To: David Lloyd **From:** Mike Nugent
Fax: 772-4056 **Date:** July 17, 2003
Phone772-6022 **Pages:** 1
Re: 41 State St. Casco Terrace 044 B023

I am reviewing technical submissions for the above project and have the following questions:
PARTIAL LIST

NORTH & SOUTH ELEVATIONS

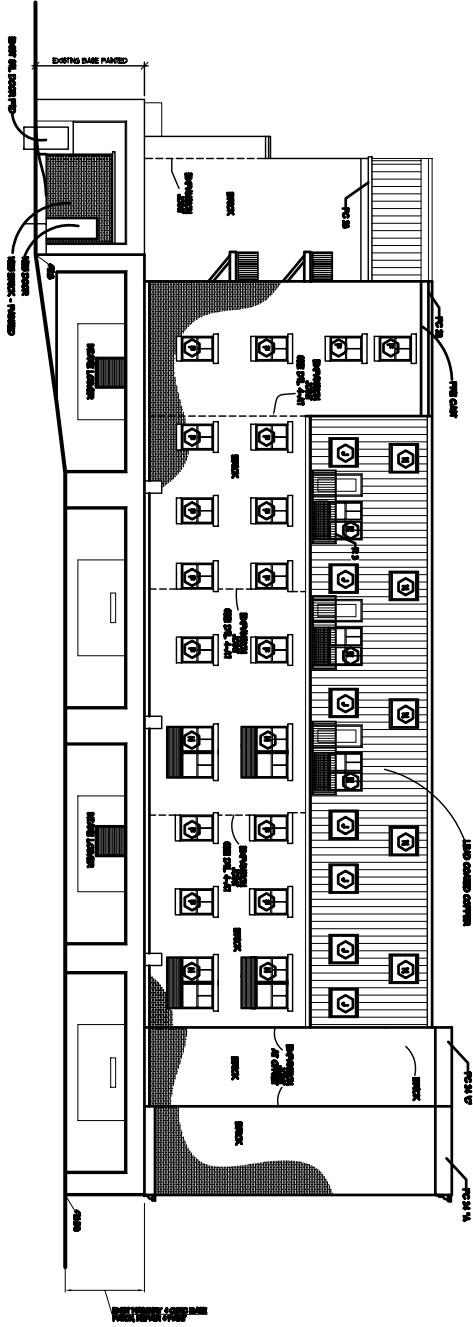
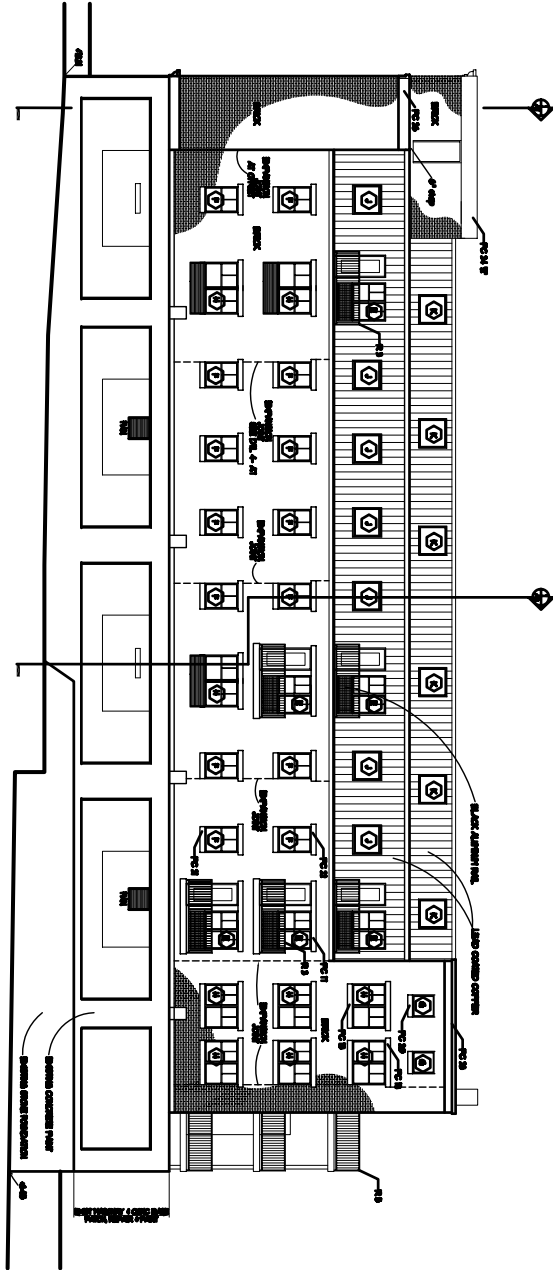
- 6) How will the trash room be rated?
- 7) Please provide code justification for the omission of a parapet wall (Section705.6) .
- 8) What is the glazing ratio for the East elevation

- 9) In order to increase the allowable openings on the North and South elevations to 15%, the sprinkler system must be a full blown NFPA 13 system, **not 13R.**

WALL SECTIONS	May 28, 2003	Project:	ARCHETYPE, P.A.	Developer:
	1/2" = 1'-0"	CASCO TERRACE	ARCHITECTS	MAINE WORKFORCE HOUSING, LLC
	Revisions	41 STATE STREET, PORTLAND, MAINE	48 Union Wharf Portland, Maine 04101 (207) 772-6022 Fax (207) 772-4056

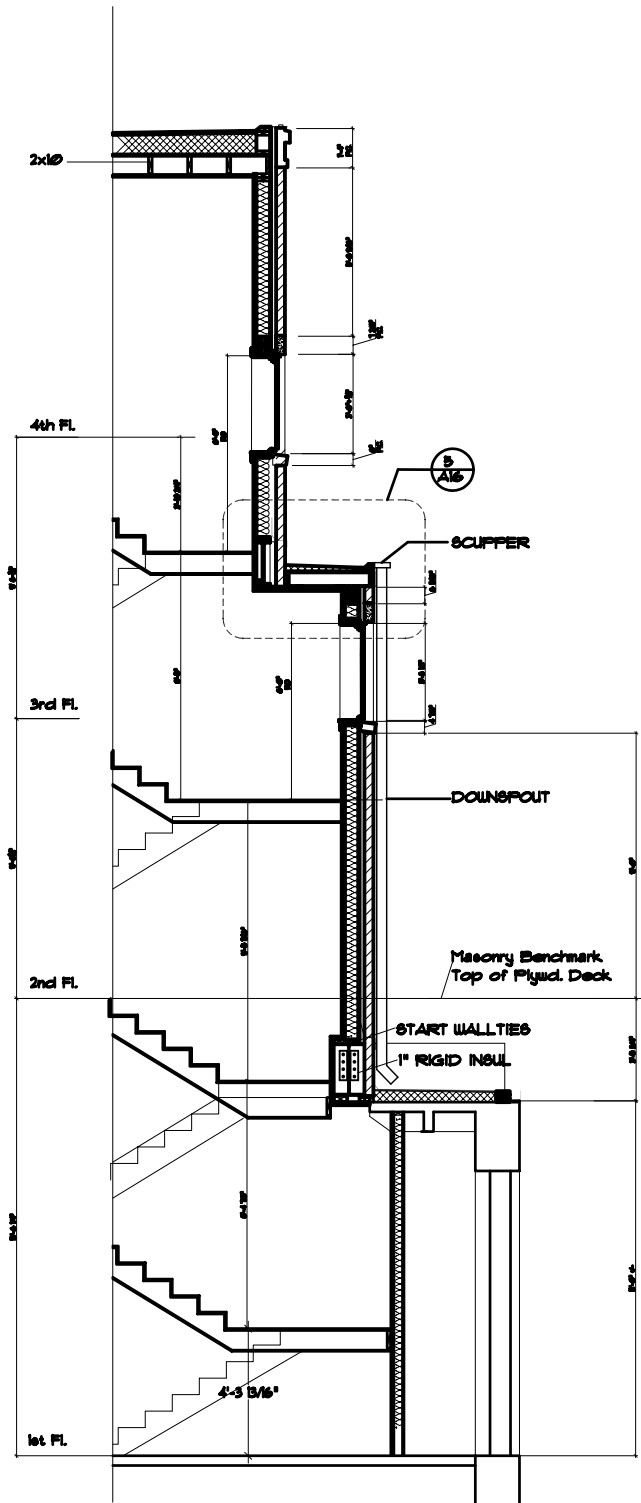
- 12) The Guard system for the deck with the upside down half moon detail would present a pattern that is a ladder in effect and not be allowed .
- 13) There is no ballusters on the mechanical room stairs.

DETAIL PLANS
 TYPICAL UNIT TYPES

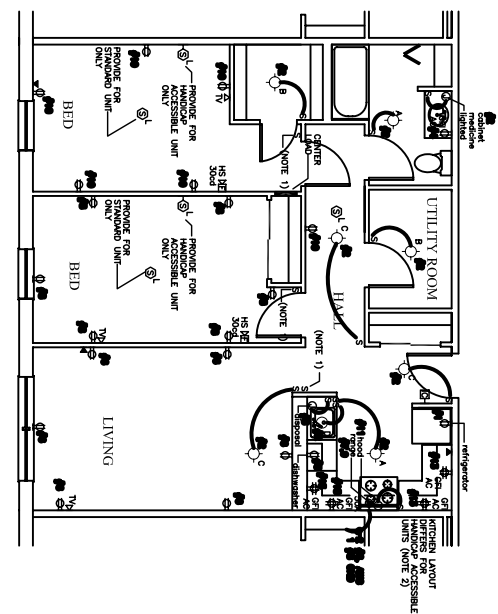
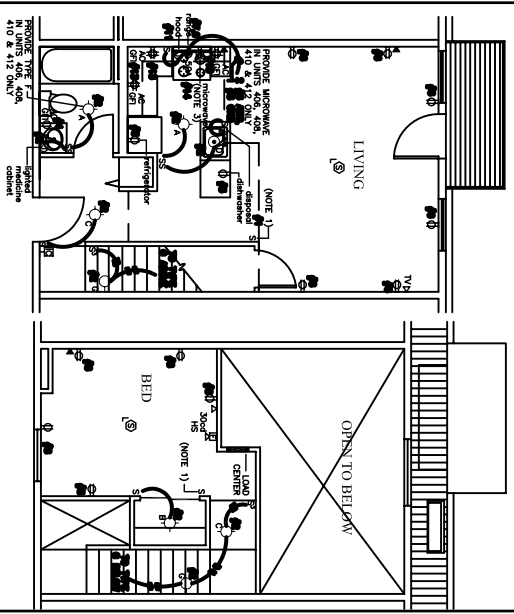
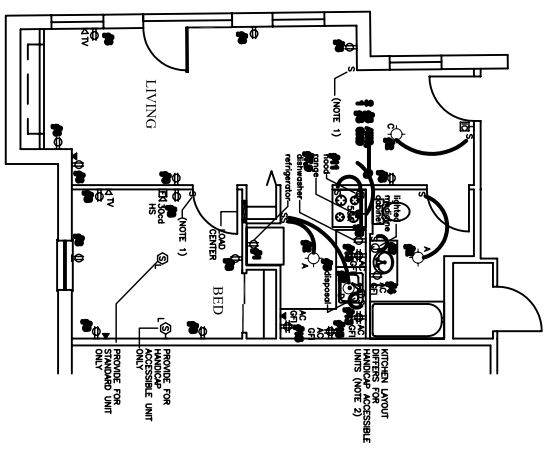
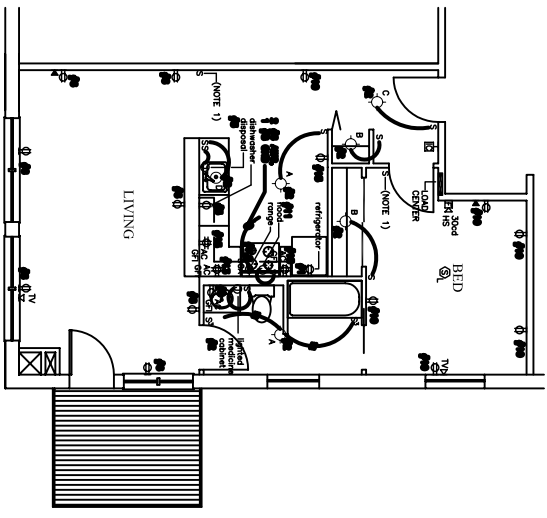
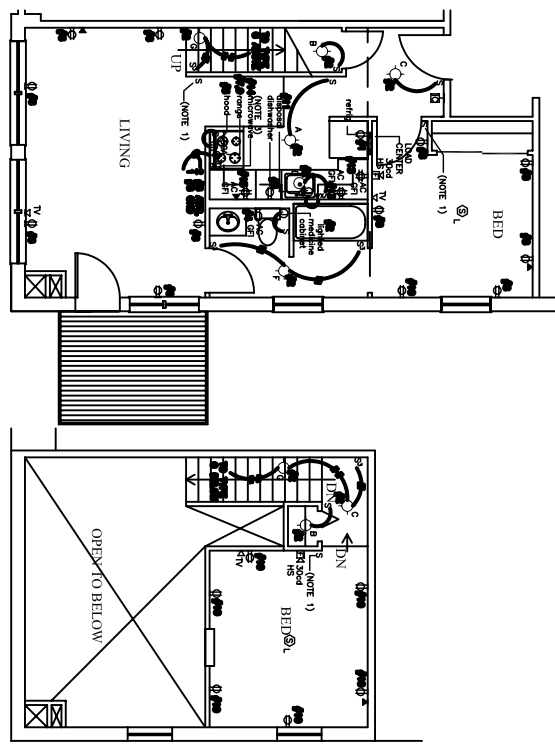
- 4) Mezzanines appear to exceed the 1/3 rule units 402 through 412, significantly (50%) unit 409-37%
- 5) Please provide info about the garage ventilation establishing compliance with the 1993 BOCA Mechanical code and exterior noise levels generated.
